Demolish 1 house (60 Sea Lane); partially demolish 1 house (45 The Ridings); construct 3 detached houses; alterations and extensions (45 The Ridings)
45 The Ridings and 60-62 Sea Lane East Preston

Thank you for your internet representation made on 22nd May 2013 which has been recorded as '**an objection**' with the comments as follows:

STREET SCENES

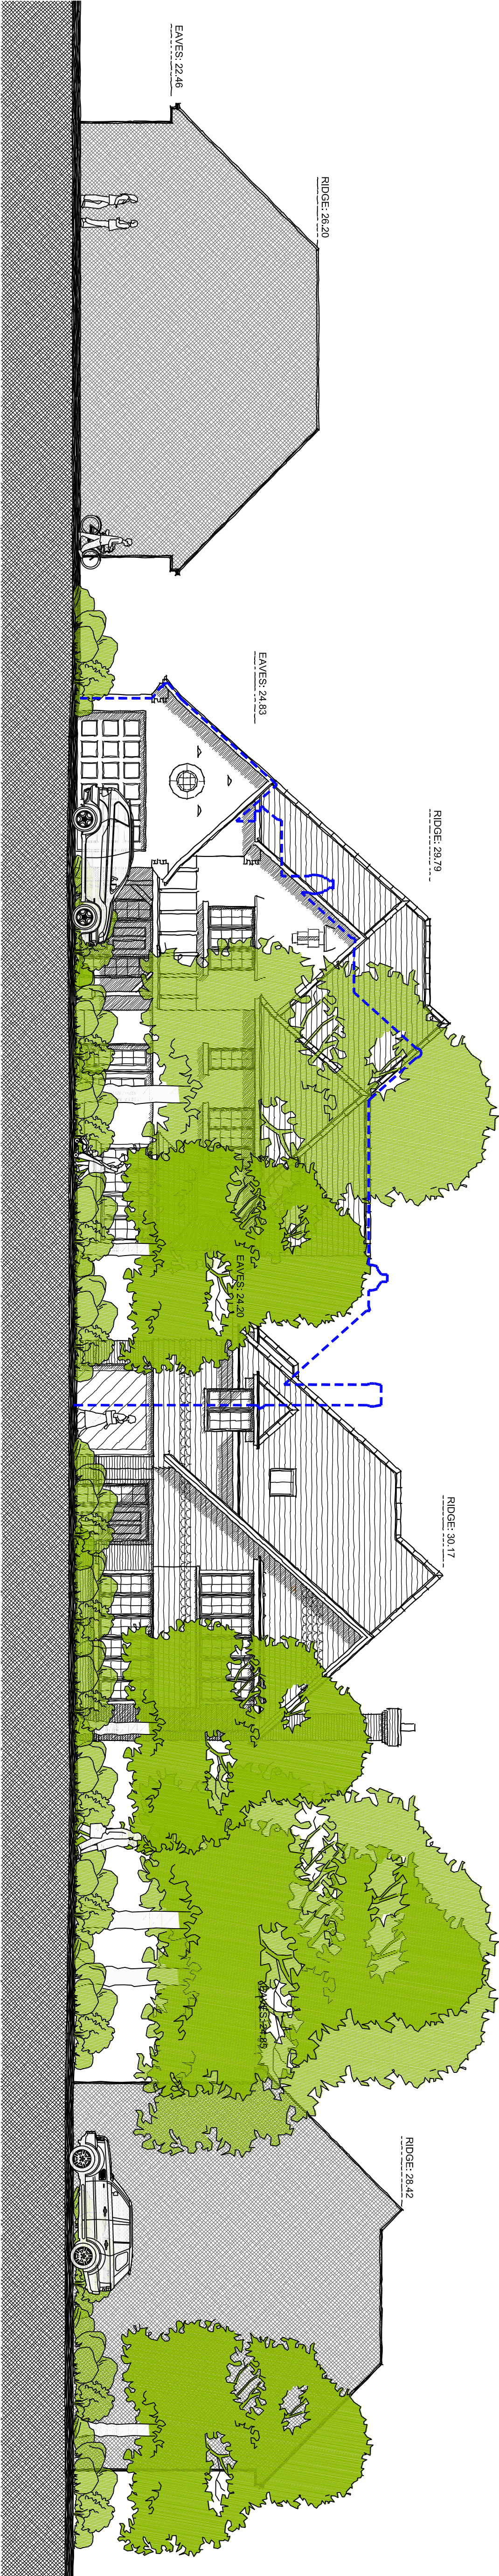
Design : The design of the dwellings is not in keeping with surrounding properties, and are overbearing in design and in roof height especially to neighbouring dwellings. This is particularly so for 43 The Ridings.
